LU/305/21/PL

17 Amstel Court Selborne Road Littlehampton BN17 5NR

Replace windows with double glazed UPVC windows (This application may affect the character and appearance of the Littlehampton Sea Front Conservation Area)

CLARE PATTEN
 17 ANSTEL COURT
 SELBORNE ROAD
 BN 17 5 NR
 WEST ELEVATION
 SCALE 1:100 @ A4
 DWG N° 17 AC/02

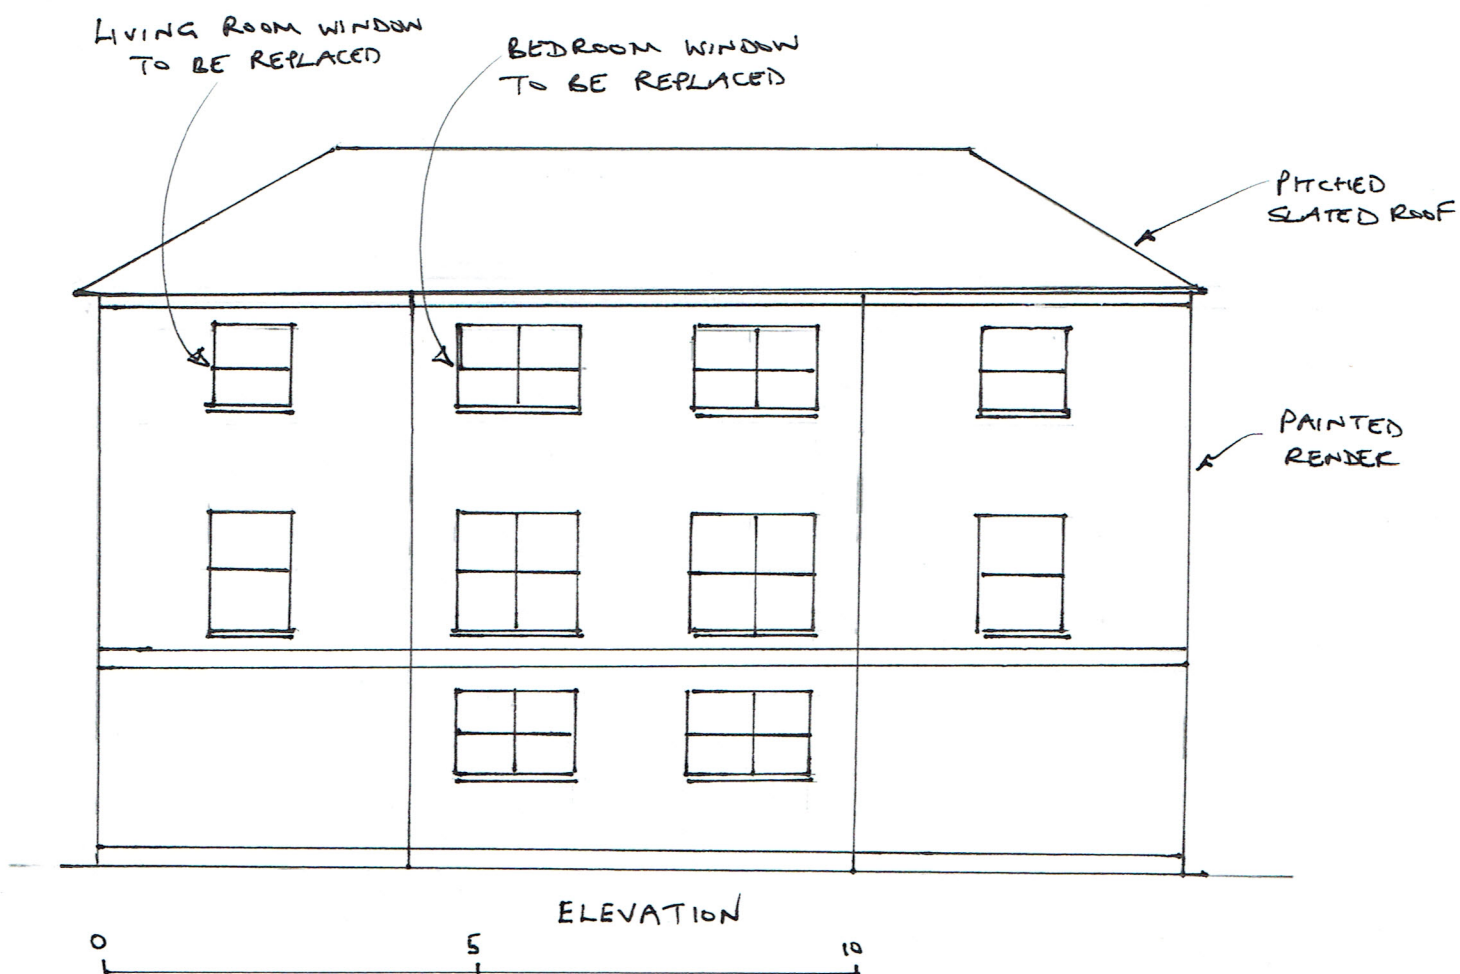
I am therefore of the opinion that the design, means of operation and materials are not appropriate for the conservation area. If you are minded to accept the use of UPVC in this particular case based on the presence of existing replacement windows, their impact could be lessened through the use of an improved window design i.e. functioning sliding sash windows. As an alternative white powder coated aluminium vertically sliding sashes could also be considered (in this instance) as an alternative, as they can have slender frame sizes which are more appropriate for a heritage context. However, at the present time, I believe that the introduction of further inappropriate windows is harmful and not capable of support from a heritage perspective.

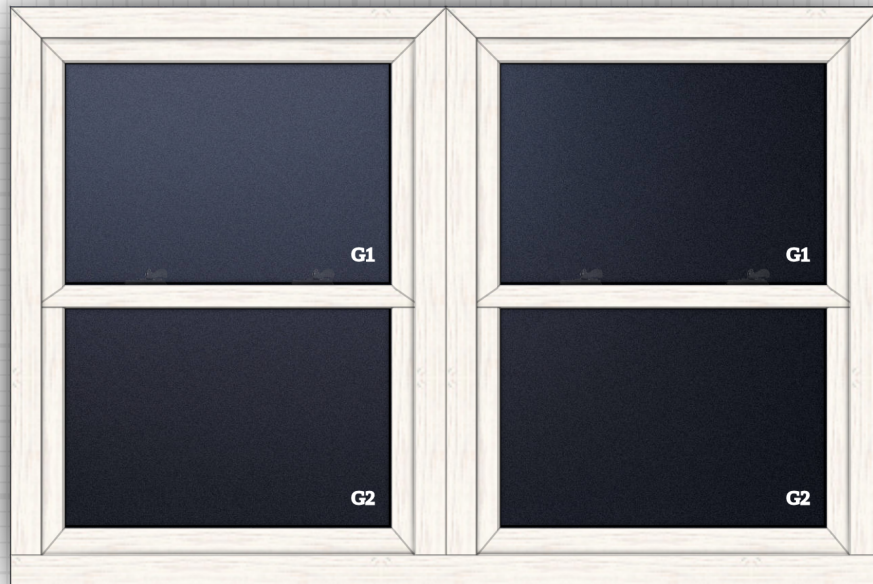
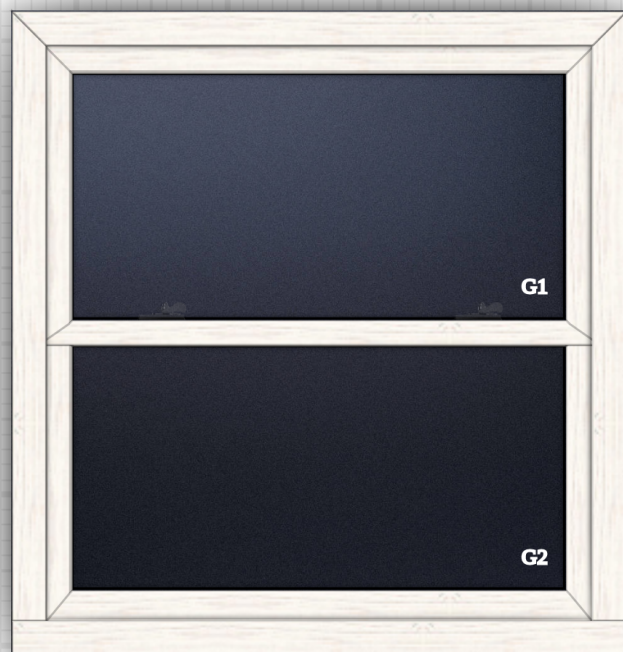
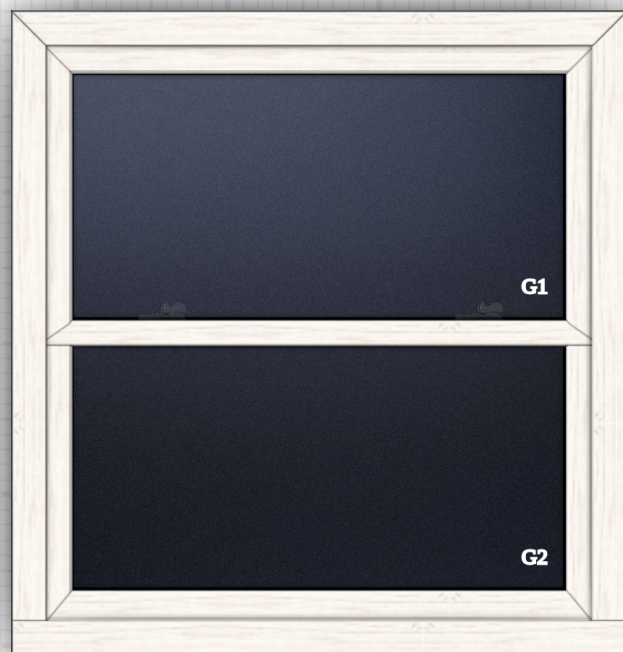
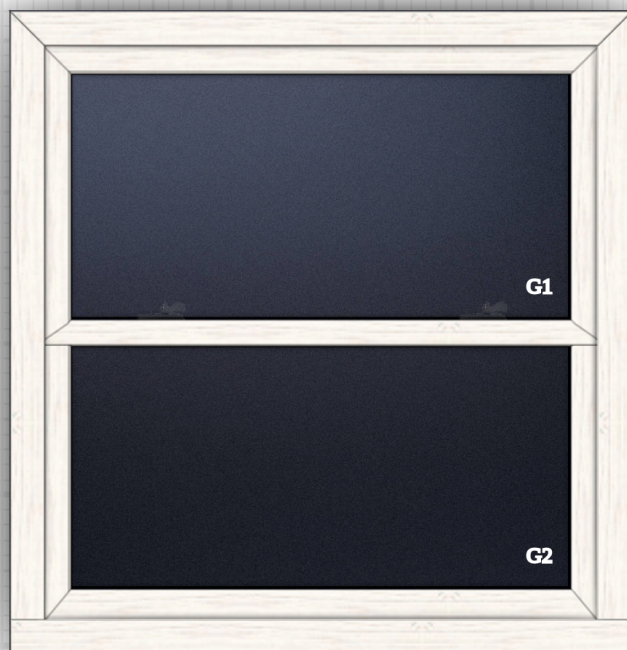
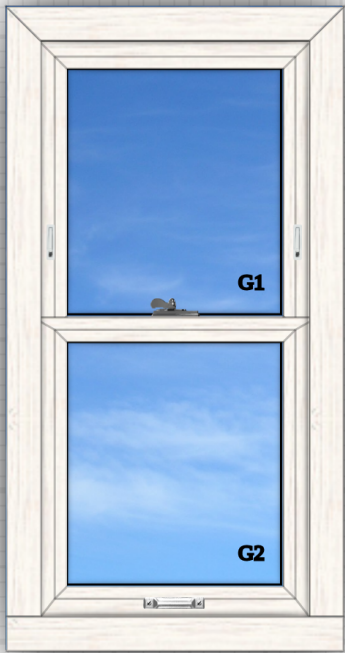
The proposal is to replace the existing timber windows in one of the apartments with double glazed UPVC windows. The window specification identifies that the replacements are to be casement windows.

Unfortunately, some of the original painted timber vertically sliding sash windows have already been replaced in some of the flats in both blocks with UPVC ones. However, these replacements are a mixture of designs or construction/appearance; some appear as sliding sash and others as 'top hung'. The top hung windows are especially considered to detract from both the appearance of the blocks of flats and the conservation area.

The design, detailing and operation of windows constructed from UPVC make them appear different to traditional windows. Standard double-glazing units usually require a bulky frame to accommodate the two panes of glass and wide spacer bars, rather than the slimmer profile of original timber windows. In addition, modern 'storm' windows, which overlap the frame rather than sitting flush, add to the width of the frames which look out of place in a historic context. The visual effect of 'shiny' modern plastic is also out of keeping with more traditional materials.
